Re: Planning Application Ref: M/39/17/HH

I have some concern about the new garage arrangement proposed for the above re-development.
My comments are as follows: -

SCALE	DATE	AUTHOR	CHK'D
1:50 @ A3	22/12/16	DS	
JOB NO.	DRAWING NO.	REV	
HANS160416	PL.05	P2	
CLIENT REF.

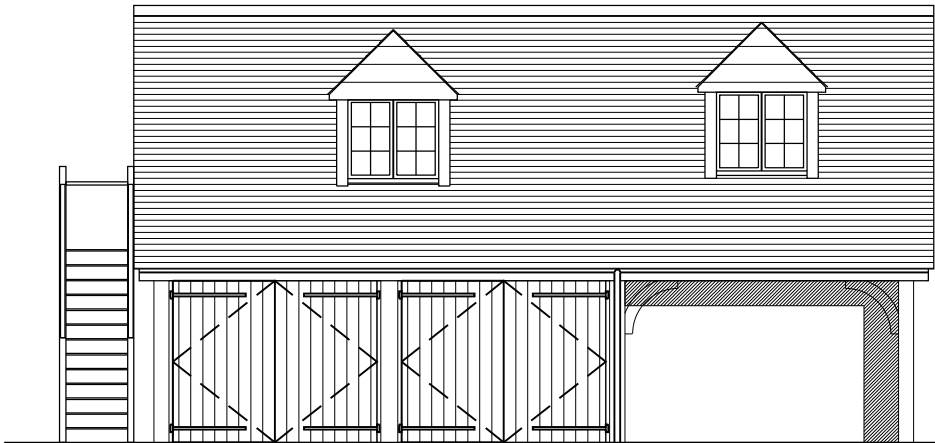
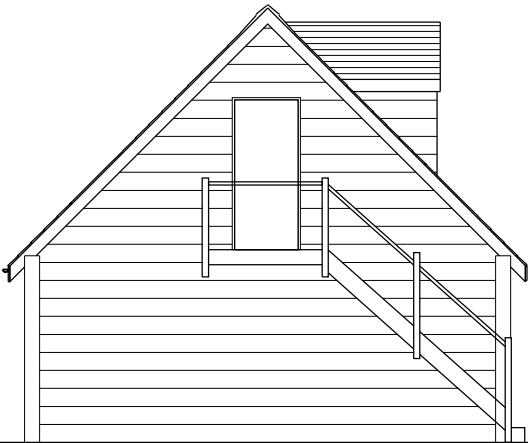
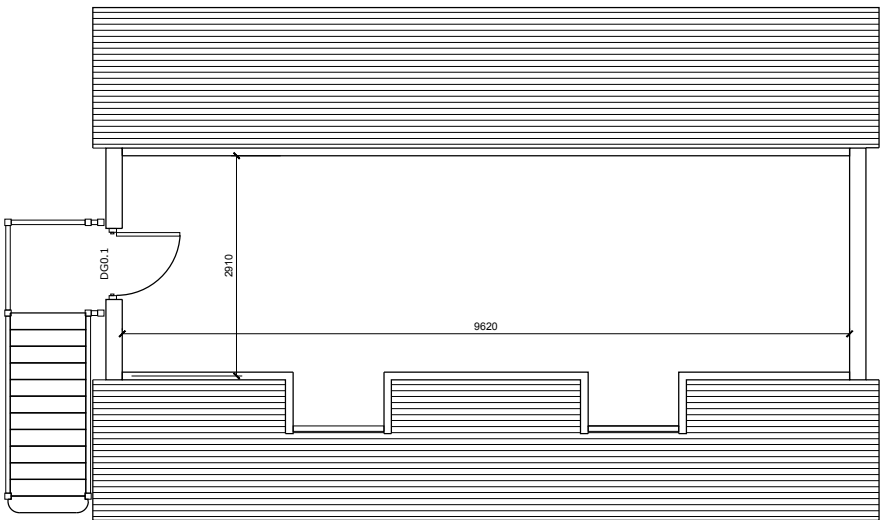
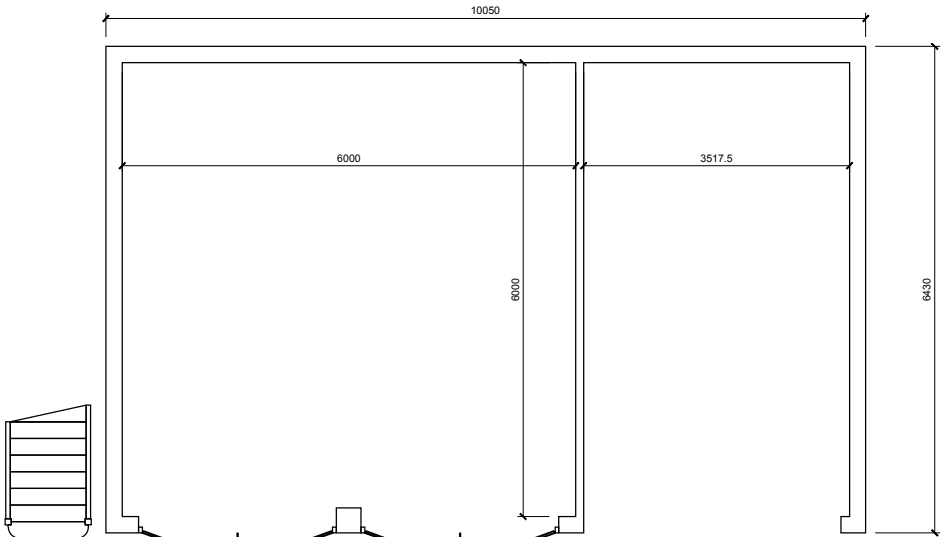
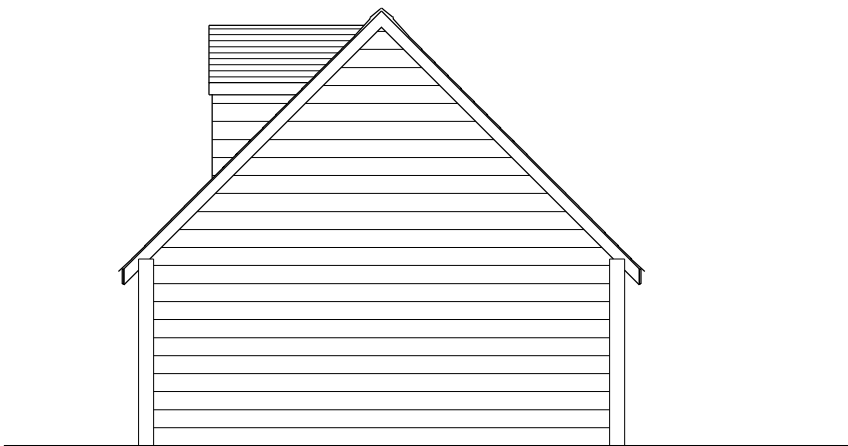
1. This building will be in front of the present building line for properties in Yapton Road.
2. This building is some five to six meters tall, way above the height of other garages in the vicinity, and is close to the road. A single storey will still house three vehicles.
3. The building materials of the side elevation facing Yapton Road need to be of a blending colour and materials, in line with the main house, whereas in the plans all appears to be just white. No specific details are given in the application.
4. If there are no tree removals, this will keep the property in line with the character of the area. With a Tree Preservation Order placed on the trees within the front garden, this protection can be achieved.
